## PLANNING CONSULTATION RESPONSE

<b>Application No</b>	2025/0583
<b>Proposal</b>	Erection of detached two-storey dwelling with associated access and garage
<b>Address</b>	Land adjacent St John the Evangelist Church, Carlton Road, Carlton, Barnsley
<b>Date of Consultation Reply</b>	02/12/25
<b>Consultee</b>	Highways DC

COPYRIGHT © 2024 PAUL HOBARTH HIGHWAY CONSULTANTS LTD 1/A PARAGON HIGHWAYS

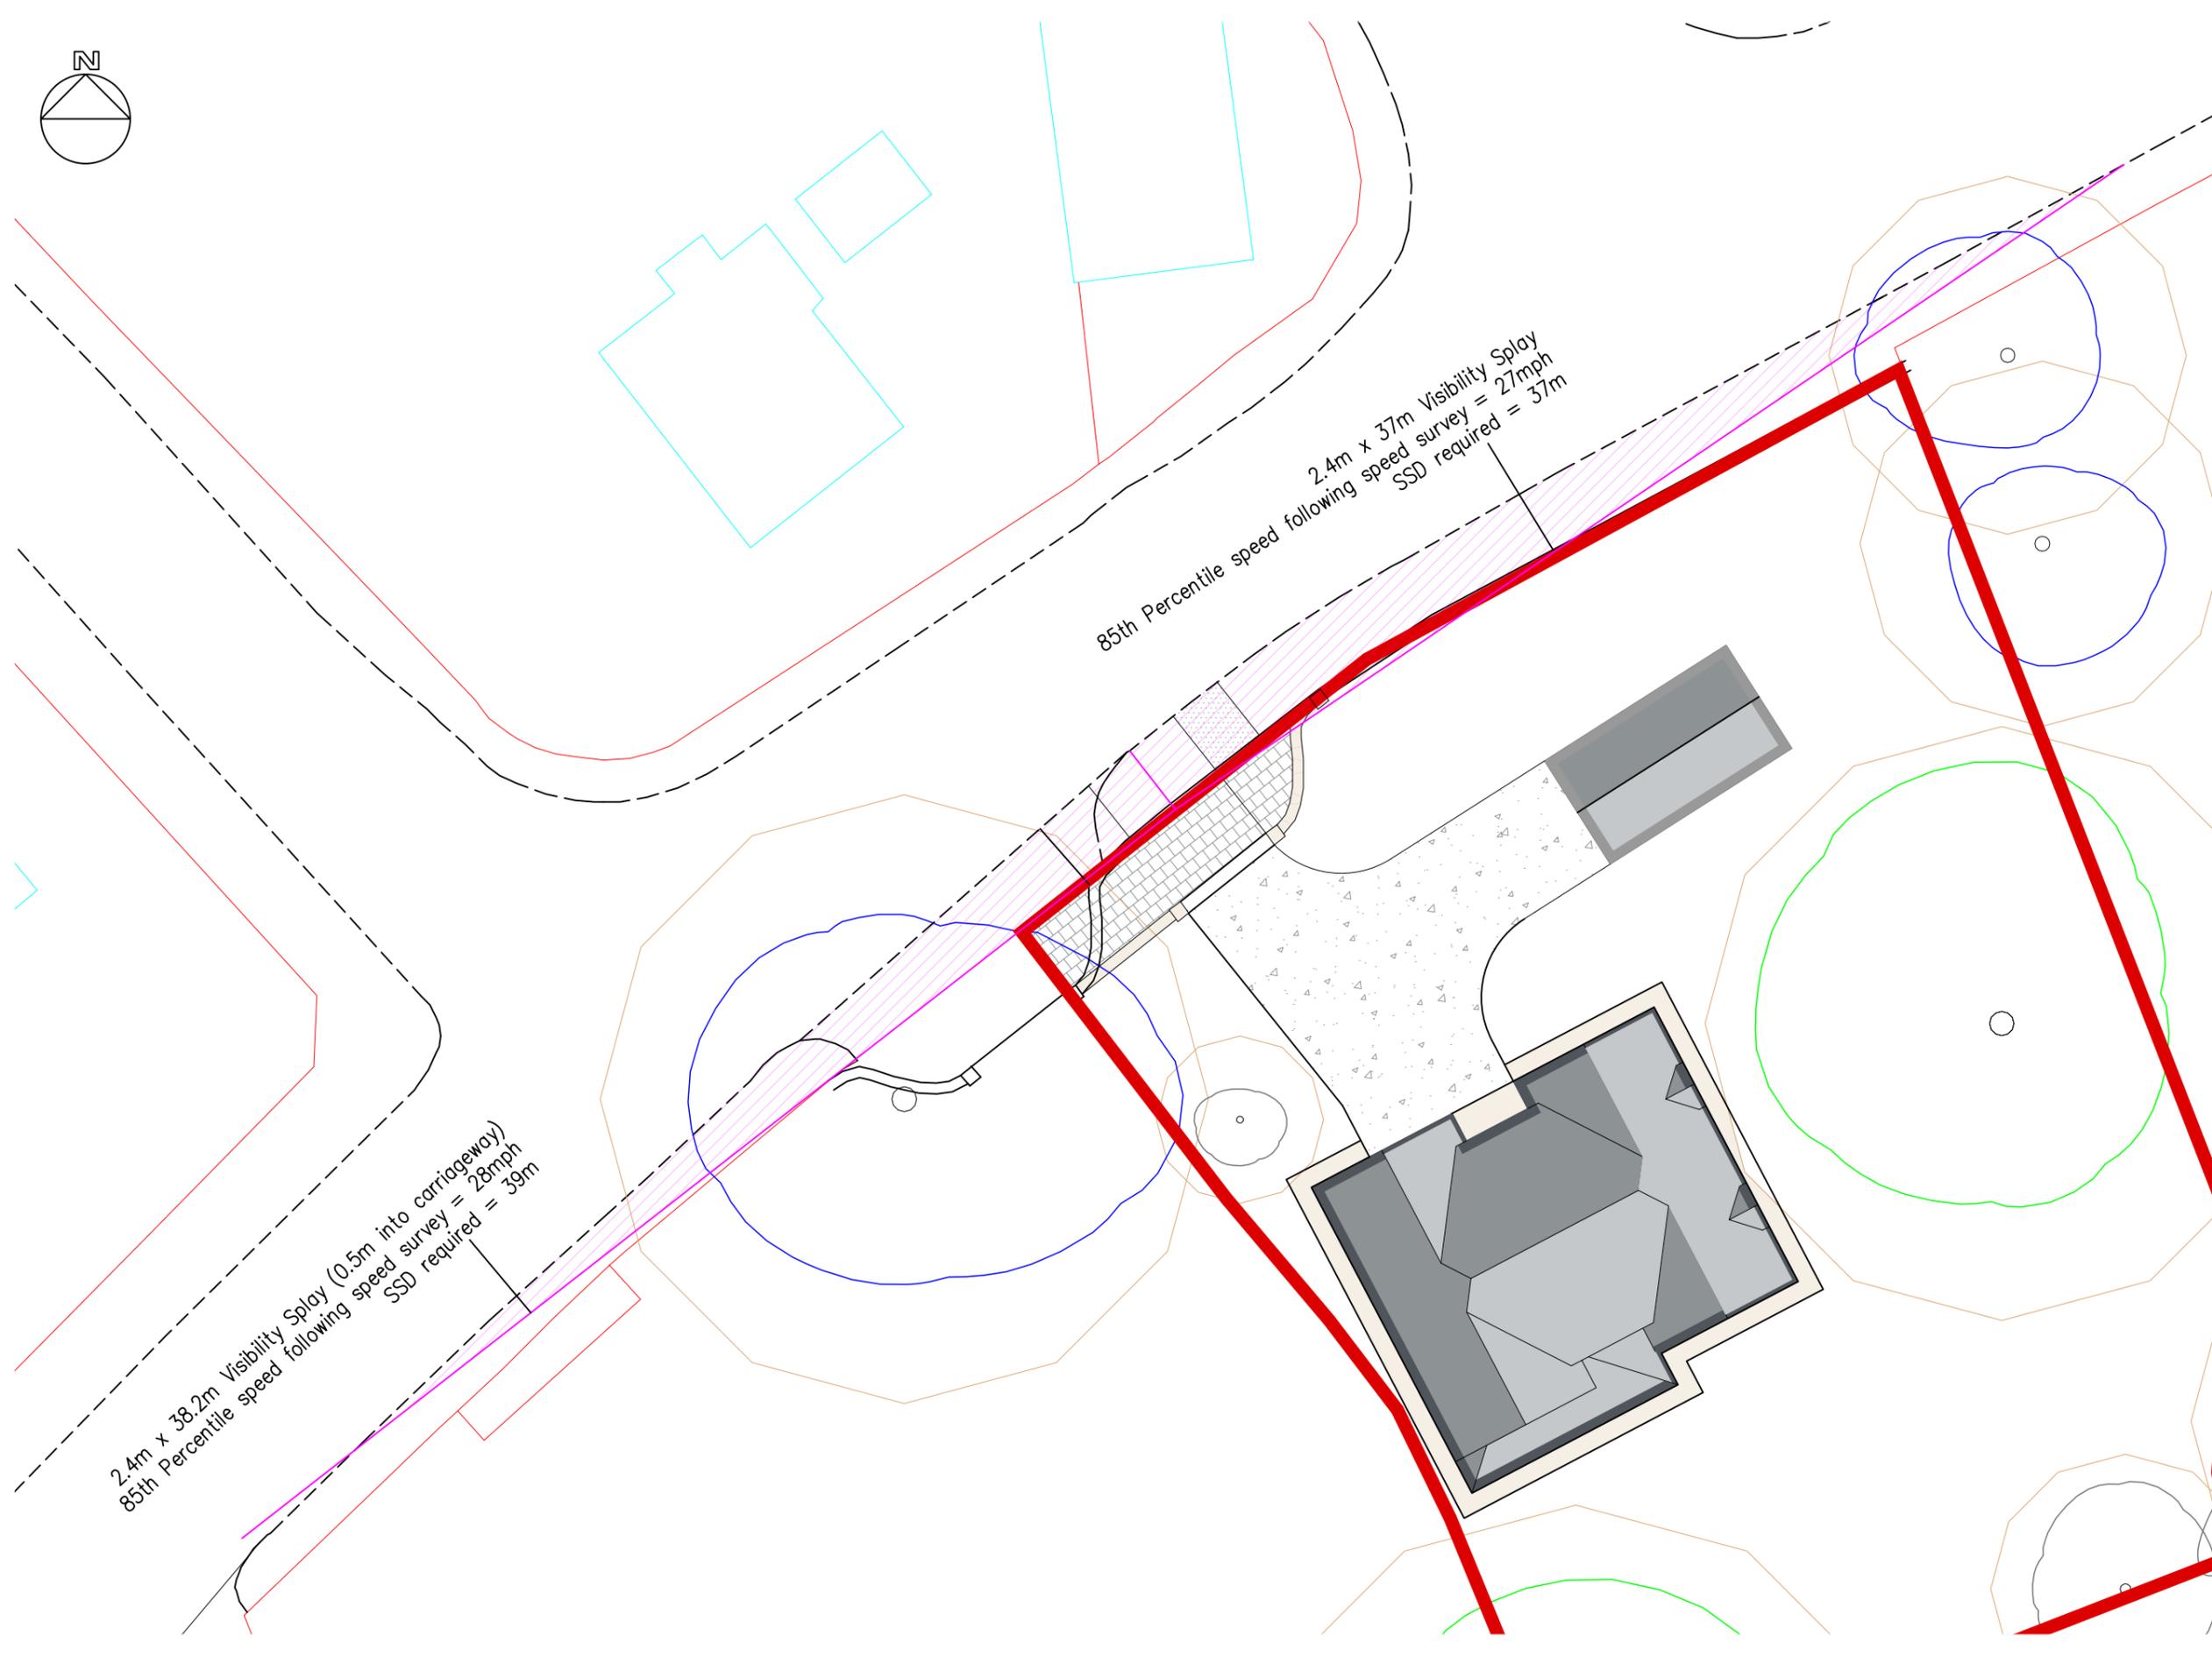
Further to previous comments, visibility splays and additional detail on the proposed access arrangement have been submitted.

Although the visibility splay to the west encroaches into the carriageway, it is acknowledged that this is in the channel of the lane of traffic coming away from the site and the splays are commensurate with the 85<sup>th</sup>-percentile speeds measured by way of an independent speed survey. This is therefore satisfactory to HDC in this instance.

The scheme is now acceptable from the perspective of highway development control. Please add the following conditions and informative to the decision notice:

The parking facilities as indicated on the submitted plan shall be surfaced in a solid bound permeable material (i.e. not loose chippings) and adequate measures shall be so designed into the proposed access to avoid the discharge of surface water from the site on to the highway.  
Reason: To ensure adequate provision for the disposal of surface water and to prevent mud/debris from being deposited on the public highway and to prevent the migration of loose material on to the public highway to the detriment of road safety and in accordance with Local Plan Policy T4 New Development and Transport Safety.

The gradient of the vehicular access/driveway shall not exceed 1 in 12 as measured from the edge of adjacent carriageway.
